Lake House - Corrections Response Letter

Building Plan Reviewer: **City of Mercer Island**

Response to: 2012-200-SUB-PLANS
Dated: April 1st, 2021
Permit #: 2012-200
Project address: 3310 97th Ave SE
Mercer Island, WA 98040

Project: Lorenzini Lake House
 Permit #: 2012-200

3 MAIN LEVEL GROSS FLOOR AREA CALCULATION - ACCESSORY BLDG AND MAIN BLDG
1/16" = 1'-0"

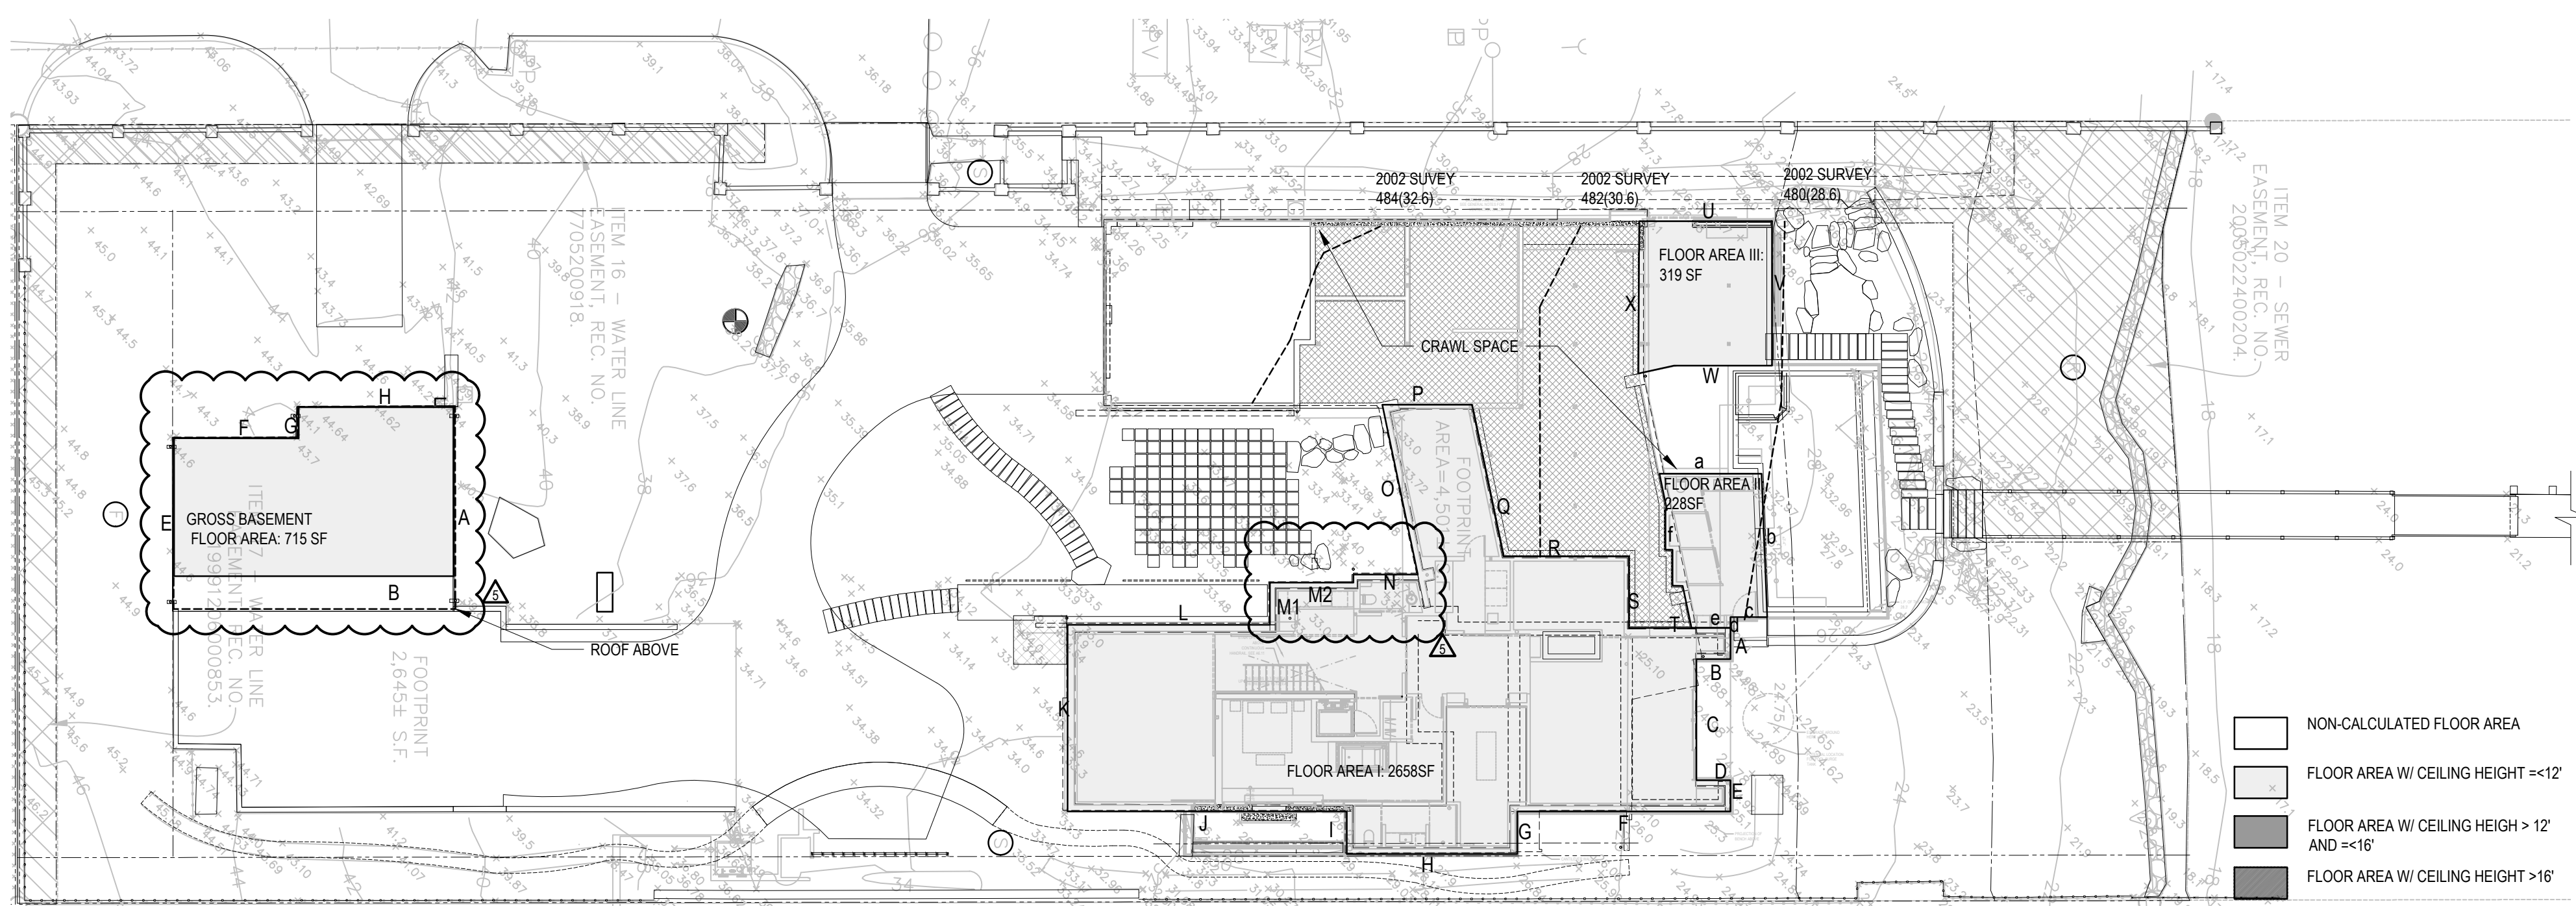
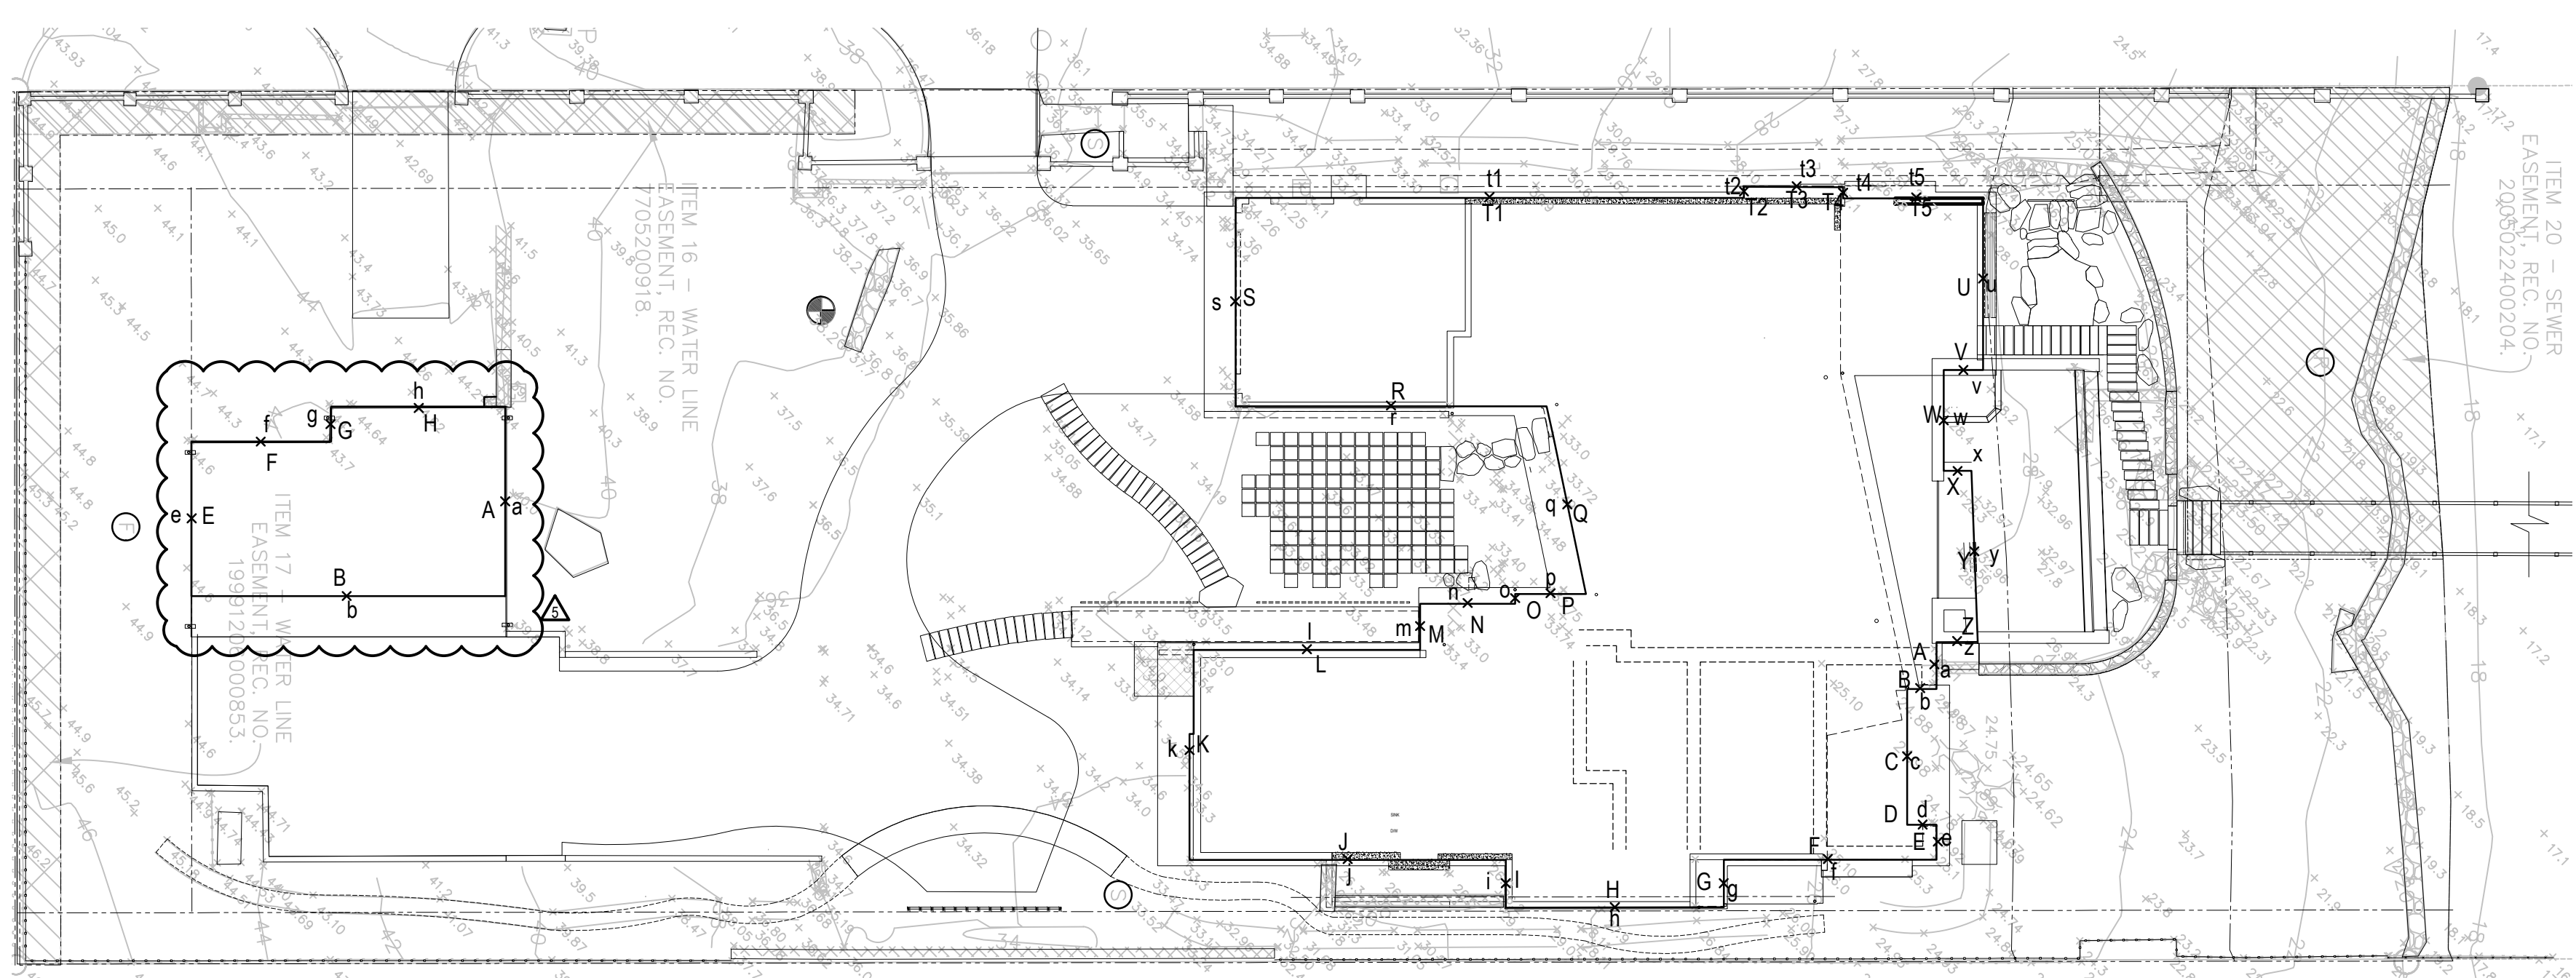
T2.01 - Second and/or third level covered decks count towards GFA. Please refer to MICC 19.16 definition of GFA. Please adjust accordingly and update the plan set and Site Development Worksheet calcs.

- **See revised code diagram 3/T2.01, covered roof decks are added to calculation**
- **See 2/T2.01 for basement area changes for GFA adjustment, which reflects changes in A4.01 and A4.02**
- **See A2.04 for changes in overhang length in respond to the GFA calculation adjustments.**
- **See A3.01, A3.02 and A3.03 for height adjustment in Great room in respond to GFA calculation adjustment**
